Recommendation Report for Planning Permission for Works or Extension to a Dwelling

REF NO: AW/102/18/HH

LOCATION: 18 The Fairway
Aldwick
PO21 4ES

PROPOSAL: Single storey front & side extensions (resubmission following AW/264/17/HH). This application affects the character & appearance of the Aldwick Bay Conservation Area.

NEW GROUND FLOOR PLAN

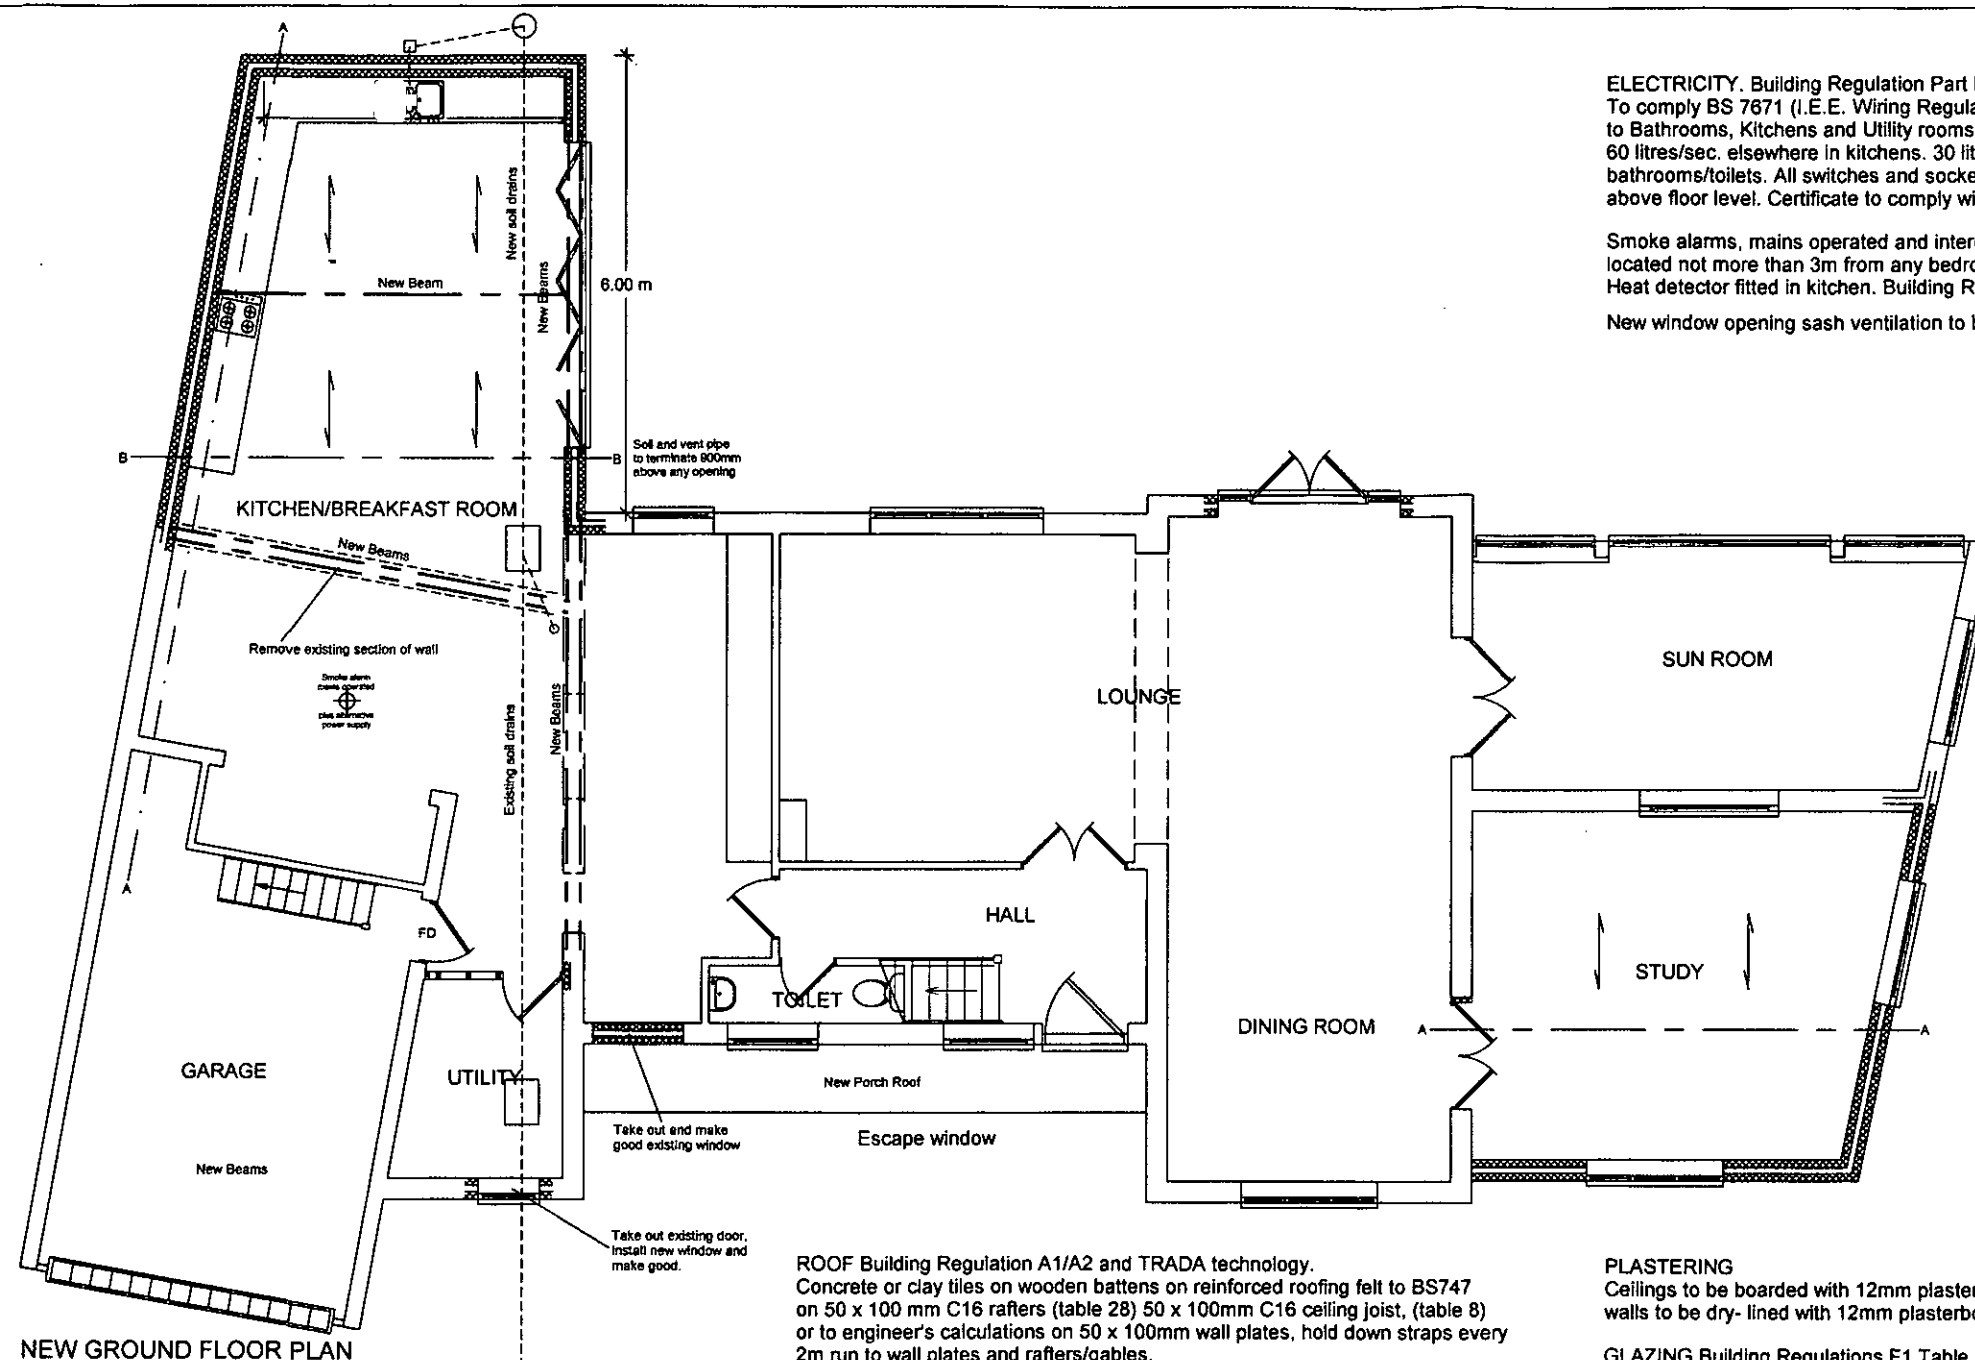
Officers note that this application does not seek permission for the 2 storey side extension as aforementioned. This application proposes the erection of a front canopy, side and rear extensions along with alterations to the external materials of the existing dwelling (removal of the existing waney edged timber cladding and replacement with tile hung half timber and painted plaster.

Whilst the previously refused application ref: AW/264/17/HH did not refuse the application on the proposed changes to the elevations of the existing building, Officers consider that any change to the existing wainey edged timber with some form of 'tile' hanging, as previously proposed, would have a detrimental impact on the Building of Special Character. Following discussions with the applicant amended plans have been received which no longer seek to remove the wainey edged timber cladding and instead seeks its retention. The applicant has stated that the external materials that are to be used are as follows:

Walls - Existing: Elm Boarding - Proposed: As existing- walls plastered and painted to match.

As aforementioned, following discussions with the applicant they now seek to retain the original external materials, in particular the waney edged timber (elm) cladding.

EXTERNAL WALLS EXISTING HOUSE

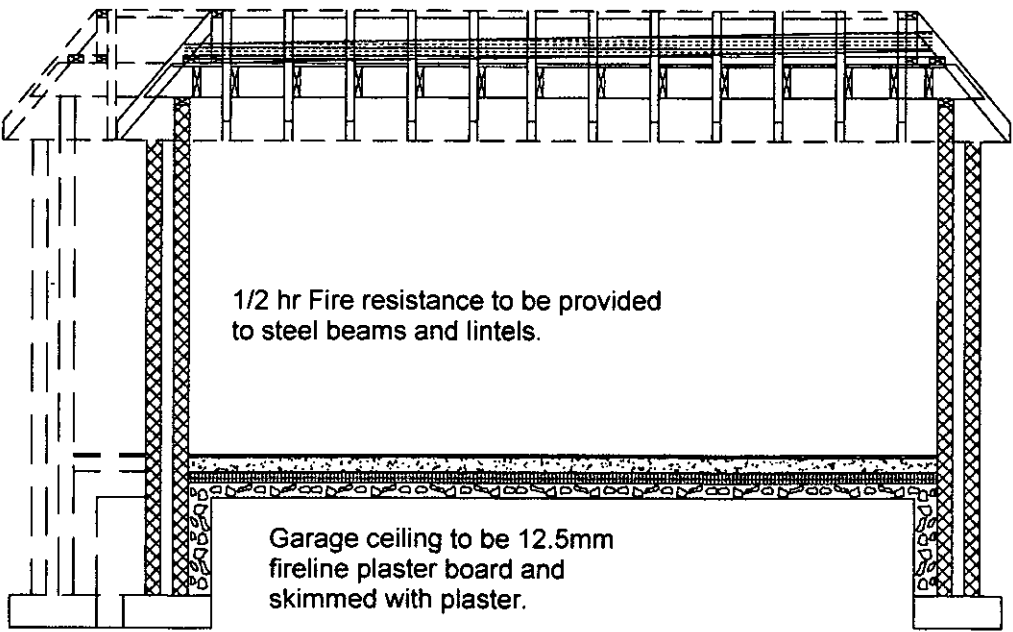
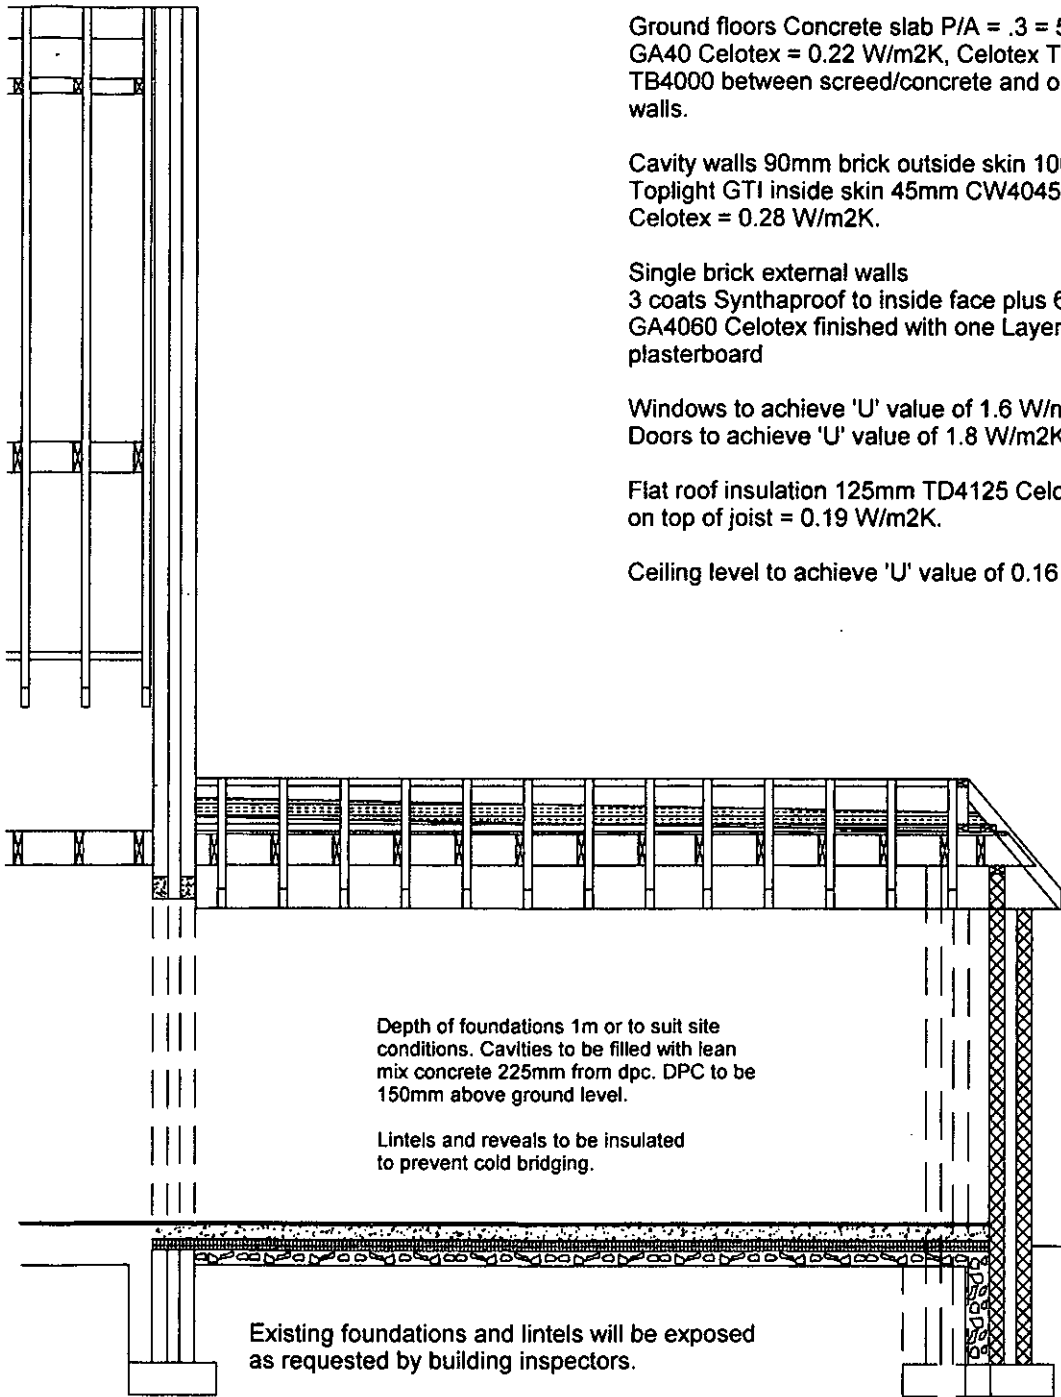
Having regard to the fact that the dwelling is a Building of Special Character Officers consider that the materials used on the application dwelling are intrinsic to the buildings special character, in particular the waney edged timber cladding and the thatched roof.

NEW WEST ELEVATION

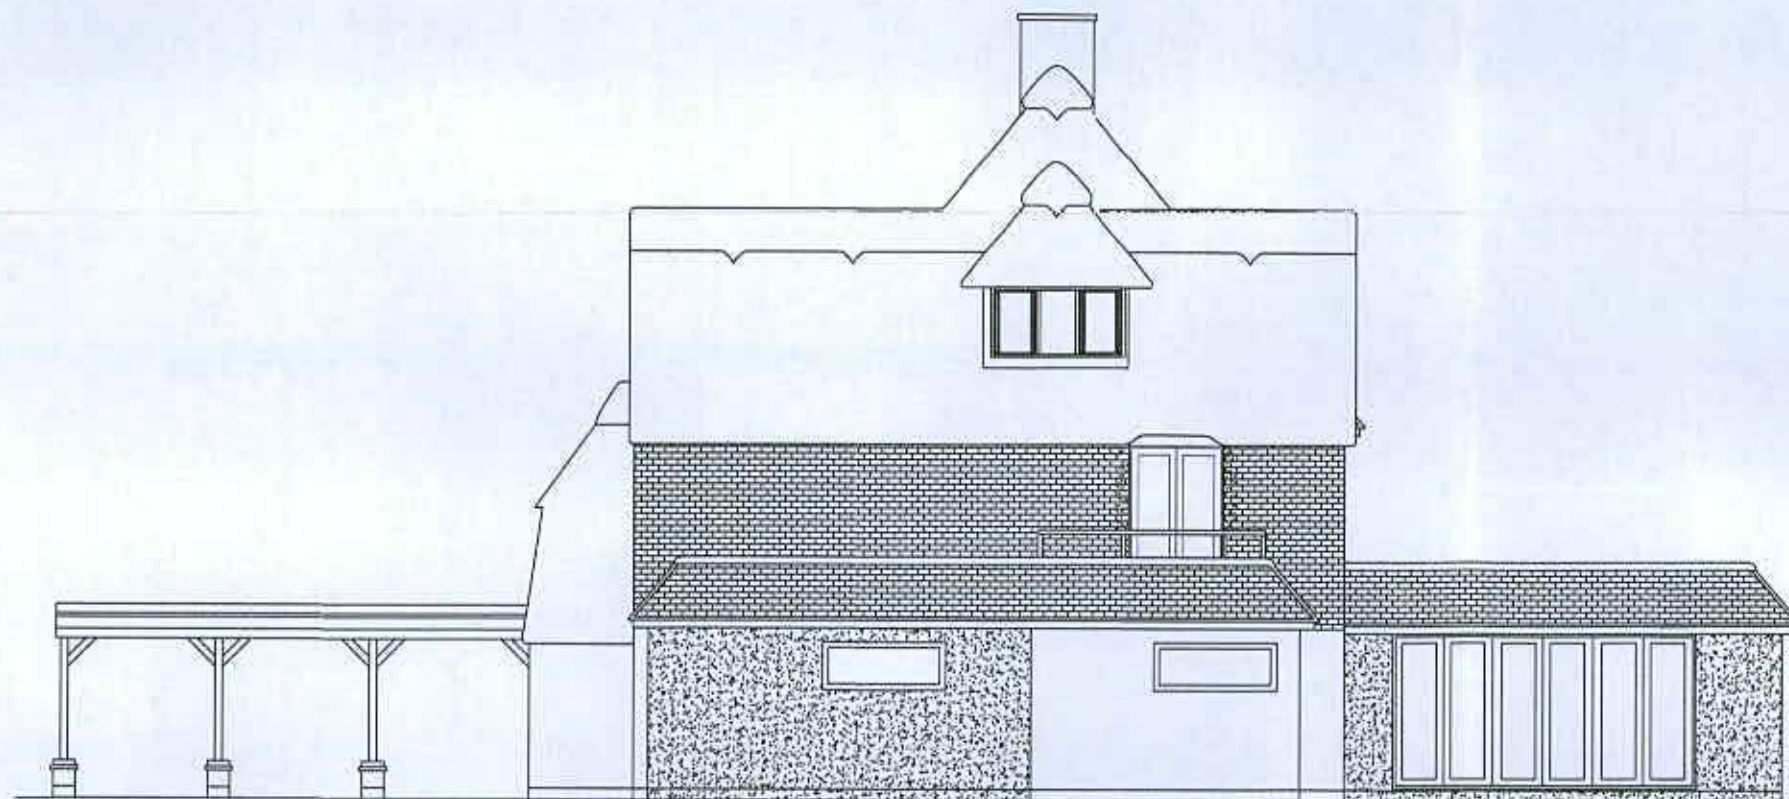
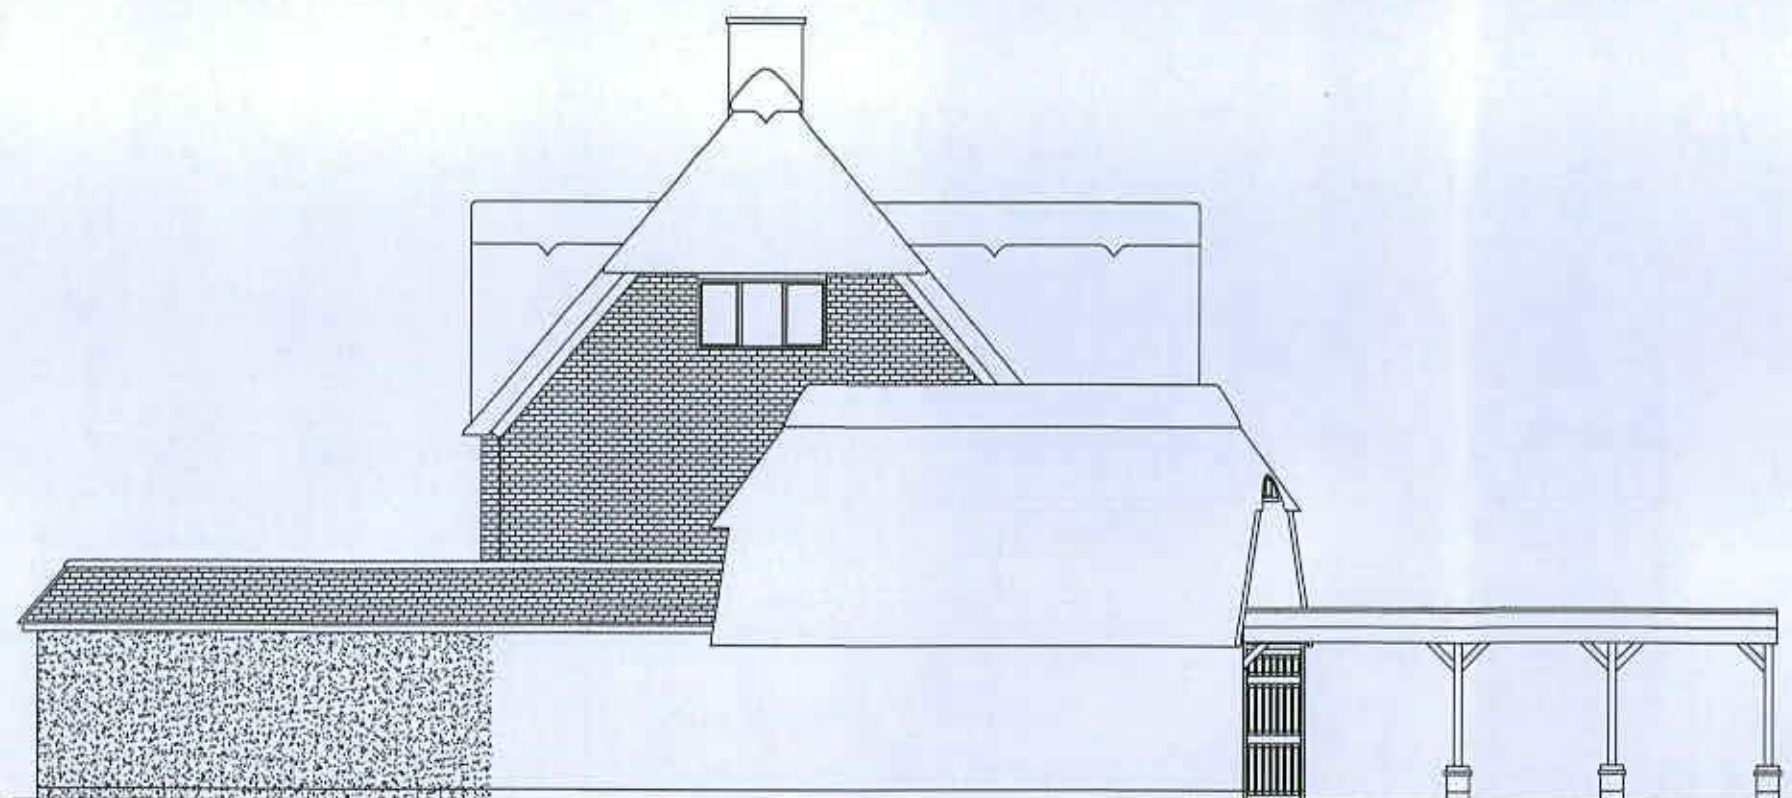
The proposed porch roof (canopy) is a feature that is seen within the area and Officers consider it to be of an appropriate size and scale. Again it is noted that pantiles are to be used atop this roof element. While the roof of the host dwelling is thatched and it would be preferable that all roof elements featured thatching, it is considered that the proposed porch roof element is appropriate and would not have a detrimental impact upon the host dwelling or the Conservation area. Additionally it should be reiterated that should permission be granted an appropriate materials condition would be imposed. Therefore Officers can control the roofing materials used and ensure that the most appropriate material is utilised, given that this is a Building of Special Character.

Also proposed is the alteration of a window at first floor in the front elevation, above the proposed porch roof (canopy), of the existing dwelling. From discussions with the Conservation Officer it is considered that the proposed window, above the aforementioned 'porch' canopy would be an enhancement to the dwelling.

Therefore, having regard to the aforementioned materials the windows, doors and walls would match. While the existing building does not feature pantiles as a form of roofing, Officers do not consider them to be inappropriate but would seek to control the proposed materials for the tiles to ensure that they are suitable. An appropriate materials condition would be imposed upon any grant of planning permission.
